Application number: 2023/90444	
What is the application for?:	Erection of detached dwelling
Address of the site or building:	Land adj, Fern Bank, Far End Lane, Honley, Holmfirth, HD9 6NS
Postcode:	HD9 6RP

Type of comment: An objection	
Do you wish your comments to be published on the website anonymously?	Yes

Project Description New Dwelling	
Site Address Land adj. to Fern Bank, Far End Lane, Holmfirth, HD9 6NS.	
Client Mr J Murray & Miss D Forbes	
Status Planning	Company AD
Drawing Proposed Elevations	
Scale @ A1 1:100	
Date March 2022	Drawn FWG
Checked •	
Drawing No. 3479 (0-) 11	Revision D

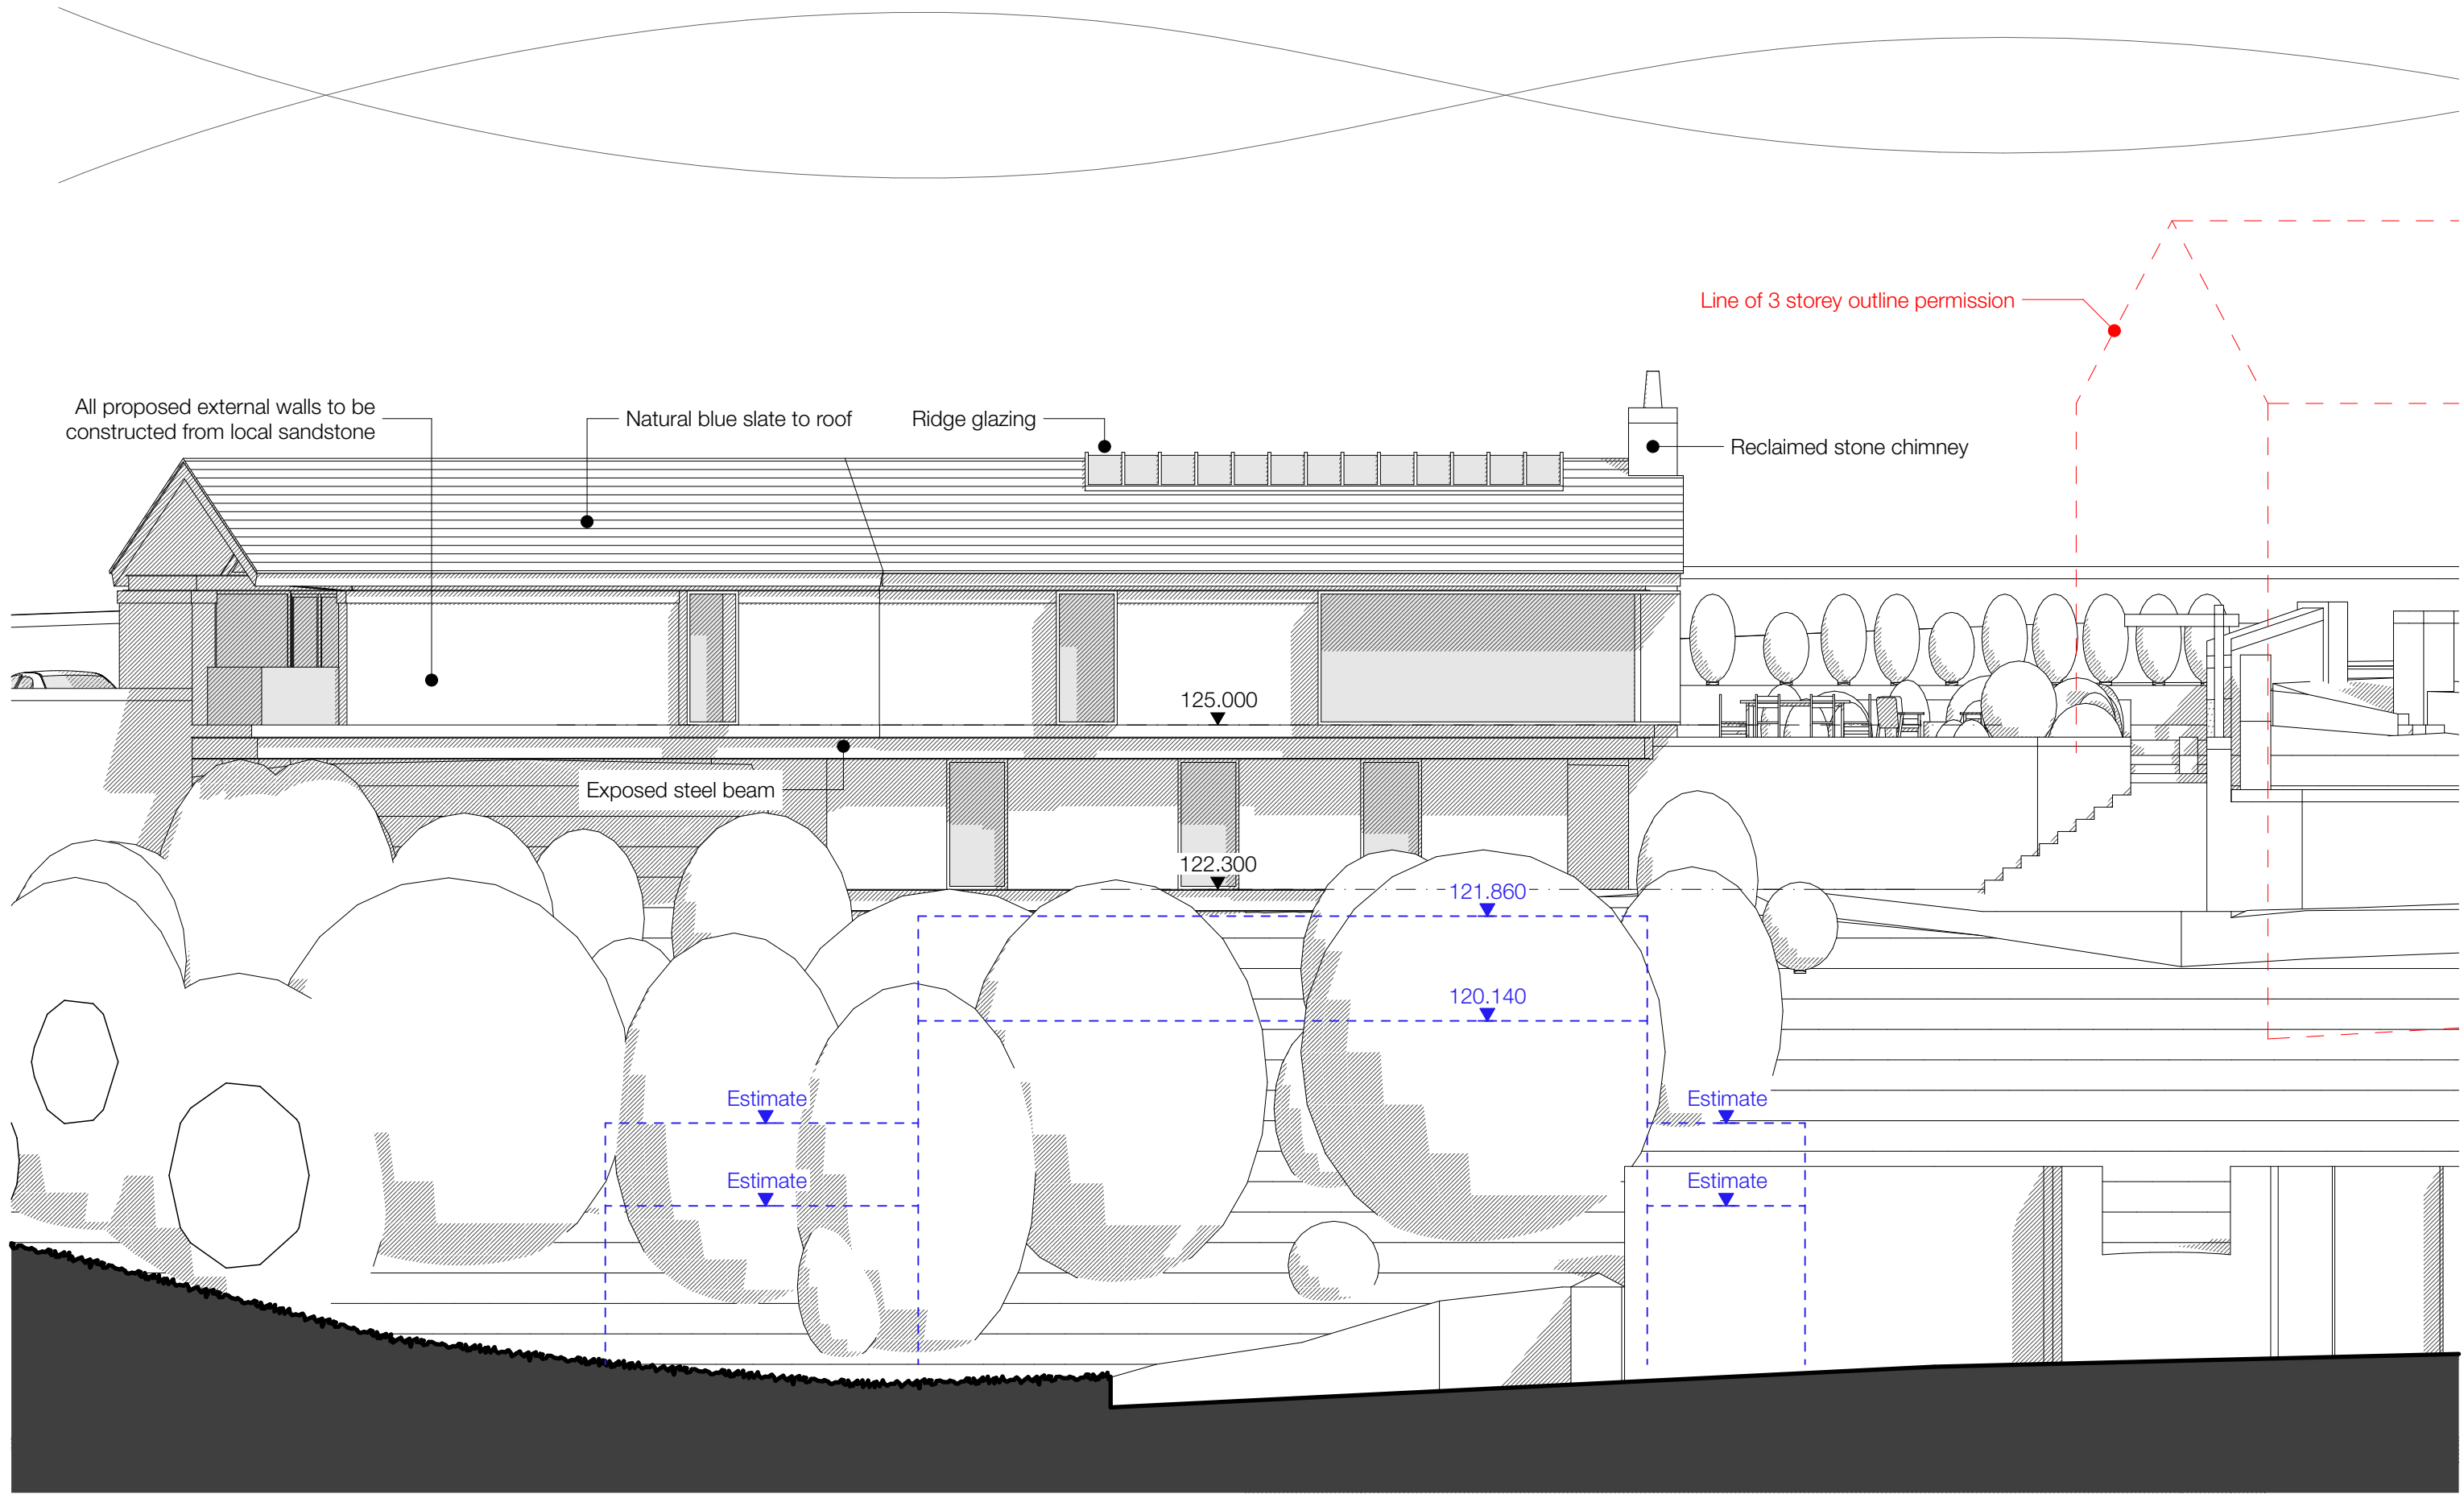
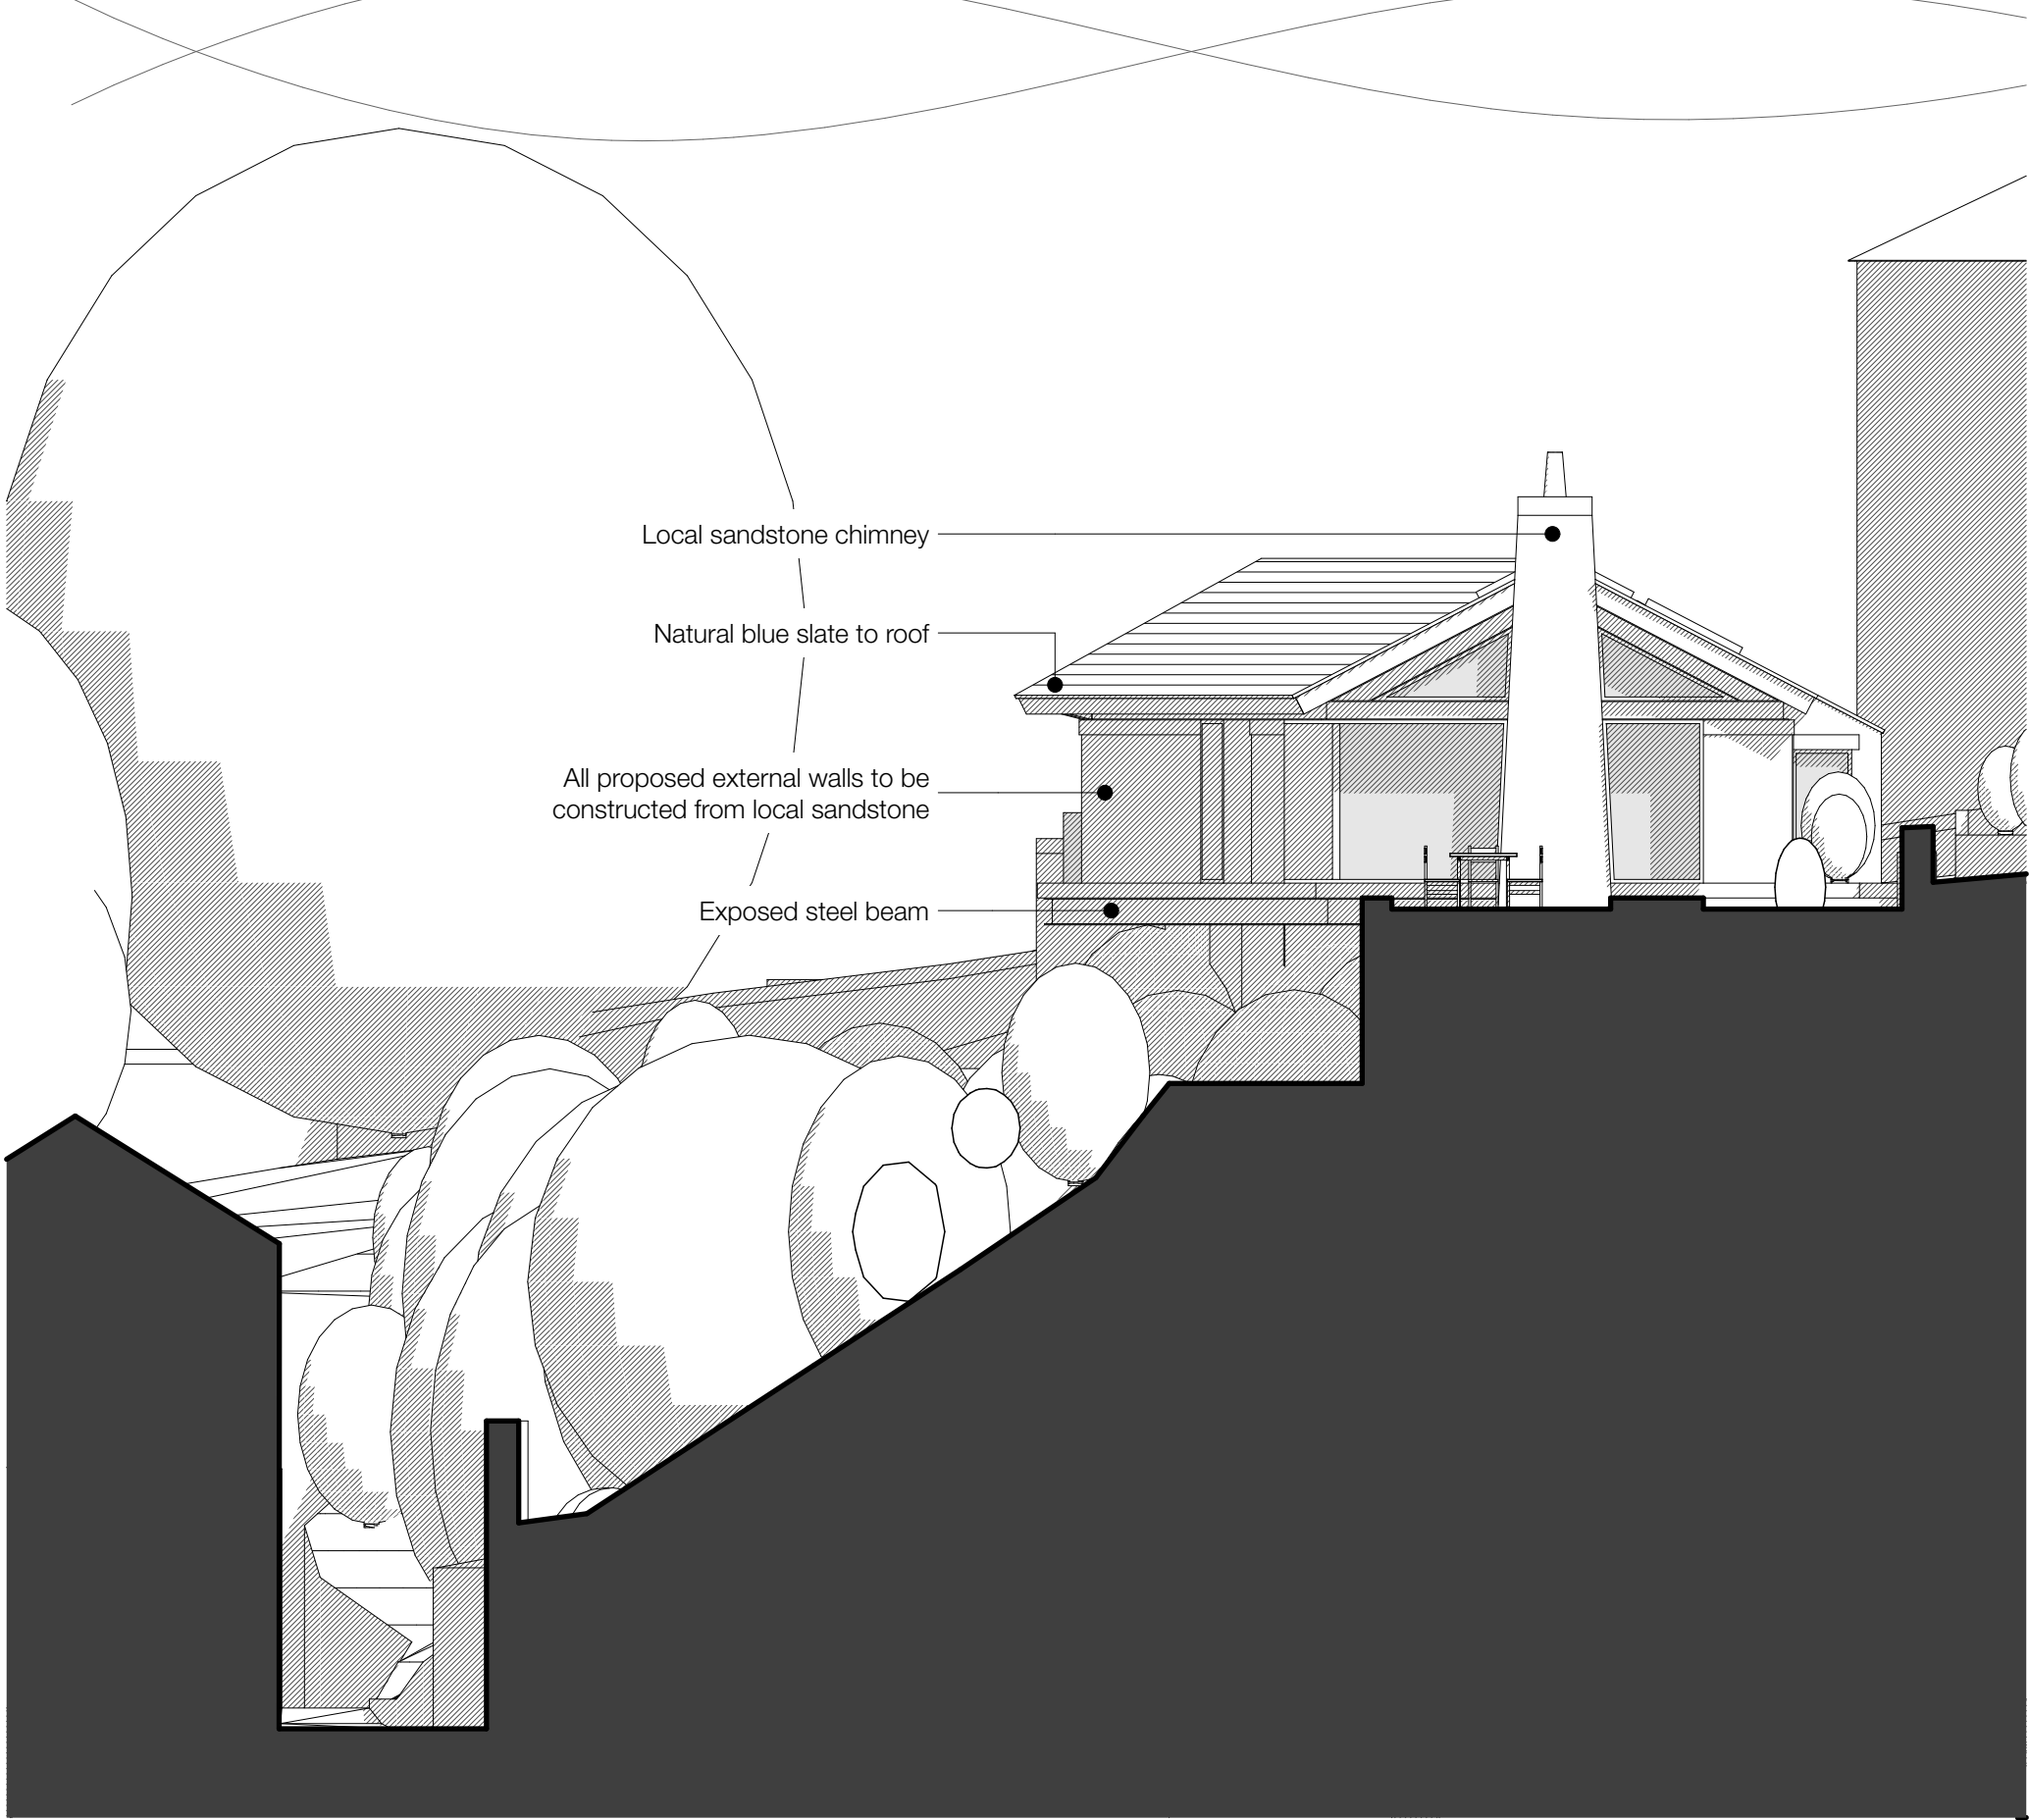
Outline Planning Permission - it has still not been explained why the footprint in this new application can differ so substantively from the Outline Planning Permission.
